# CENTRAL DARLING SHIRE COUNCIL

22 July 2013

**Re: Submission – Atlas-Campaspe Mineral Sands Project (SSD-5012)**

Figure 12: Existing Road Network (including proposed Haulage Route)

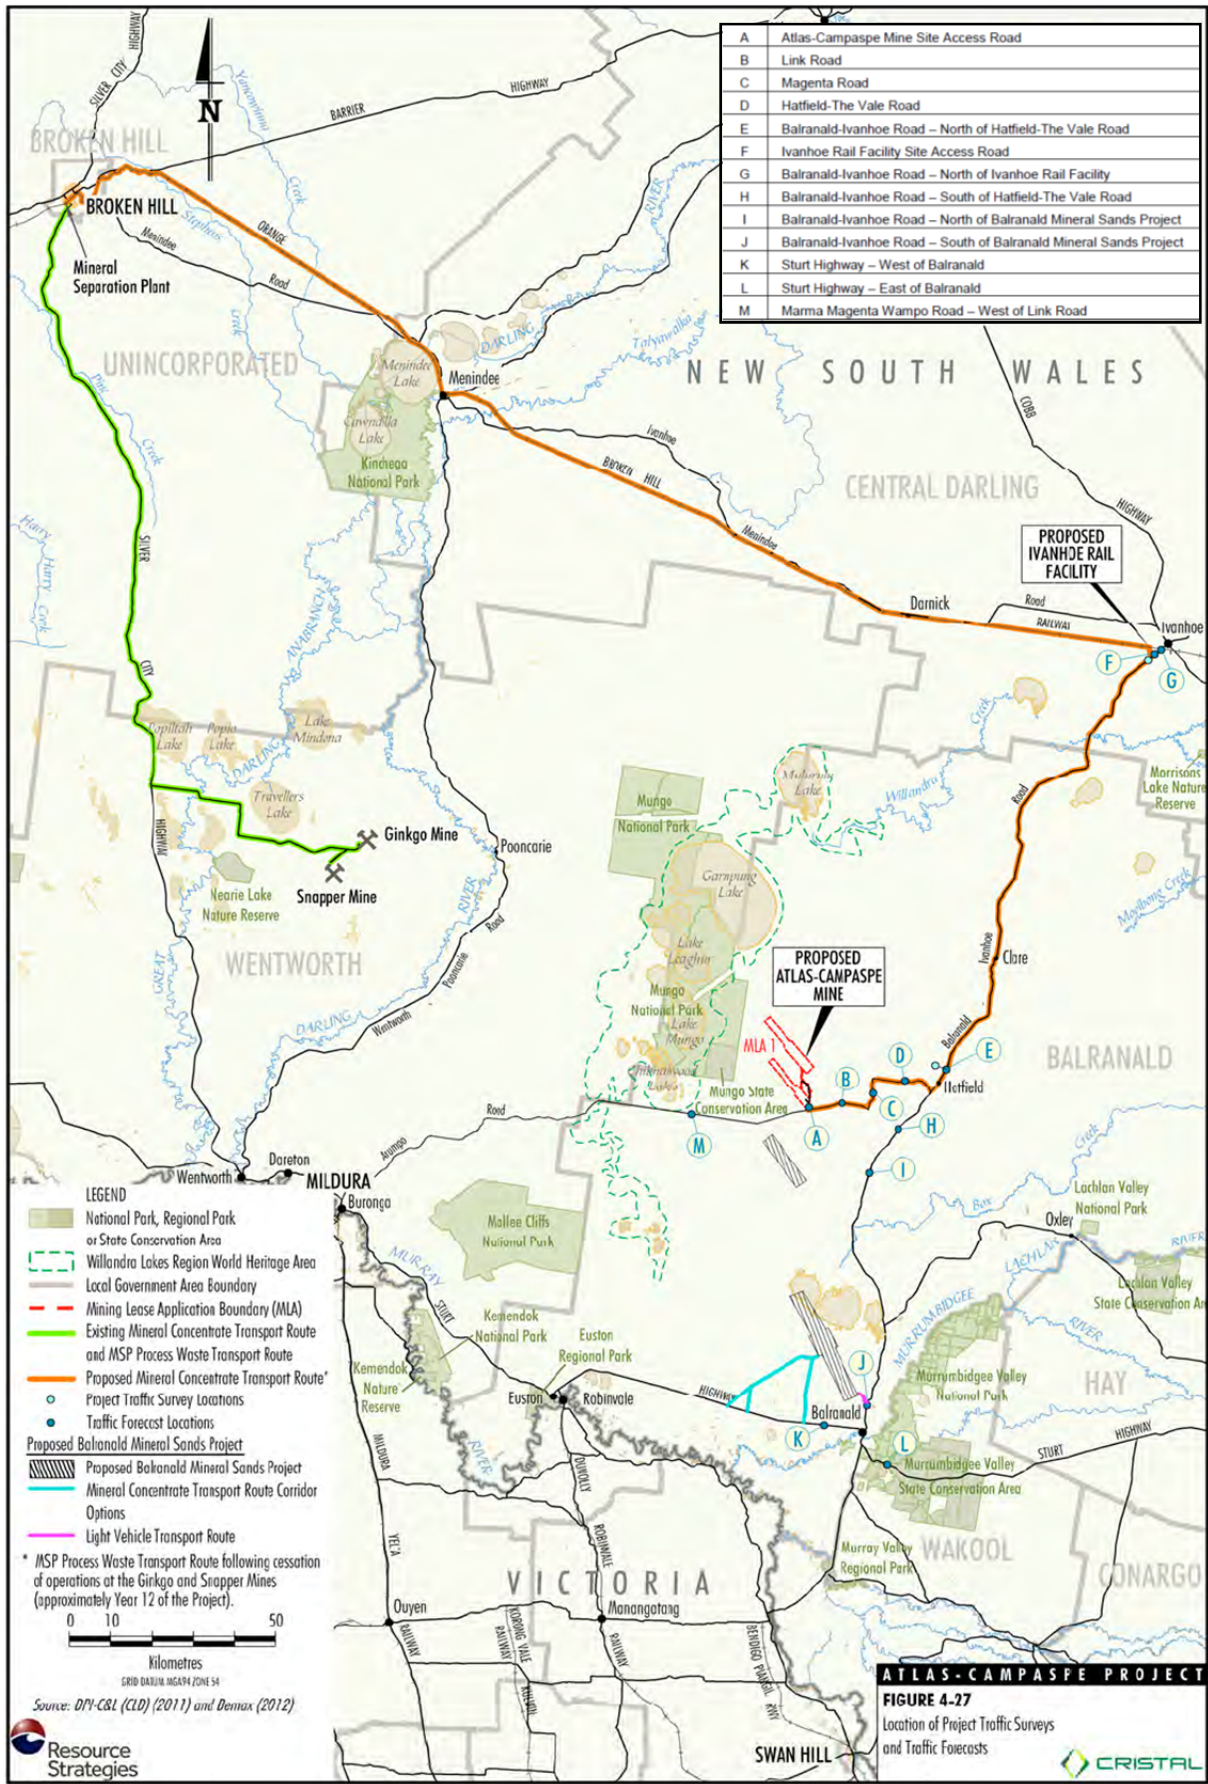
The Environmental Impact Statement has assumed that roads are sufficient for heavy haulage based on their classification for road trains. No information has been provided on the impacts of the additional haulage on the existing and proposed pavements. Failure to provide this information is a flaw in the Environmental Impact Statement and makes any deliberations as to the actual costs of maintenance difficult to quantify. Without this data, preparing and entering into Planning Agreements will be difficult to achieve as correct information is not yet available. Cristal has indicated they are willing to investigate the strength and adequacy of the pavement to address this matter.

*The EIS submitted provides an assessment of the projected traffic increase with respect to increased vehicle movements and the type of vehicles (heavy haulage). The EIS states "No significant impacts on the performance, capacity, efficiency and safety of the local road network are expected as a result of the Project." The EIS also appears to conclude that only works necessary on the Ivanhoe Balranald Rd are those identified in the Road Safety Audit prepared by GTA Consultants.*

*CDSC strongly disagree with these conclusions. The expected increase in the number and type of vehicle movements will have a significant adverse impact on pavement performance and these impacts are not adequately addressed by the works proposed within the Road Safety Audit mentioned above. Notwithstanding this conclusion the anticipated adverse impacts can be adequately addressed.*

*It should be noted that the EIS provides no assessment with respect to the existing pavement strength of the Ivanhoe Balranald Rd and how the increased heavy haulage on this road by the proposed development will impact the existing pavement.*

*The Minister in the first instance should require an assessment of pavement strength along the entire transport route including an evaluation of the existing pavements capacity to accommodate the increased loading expected.*
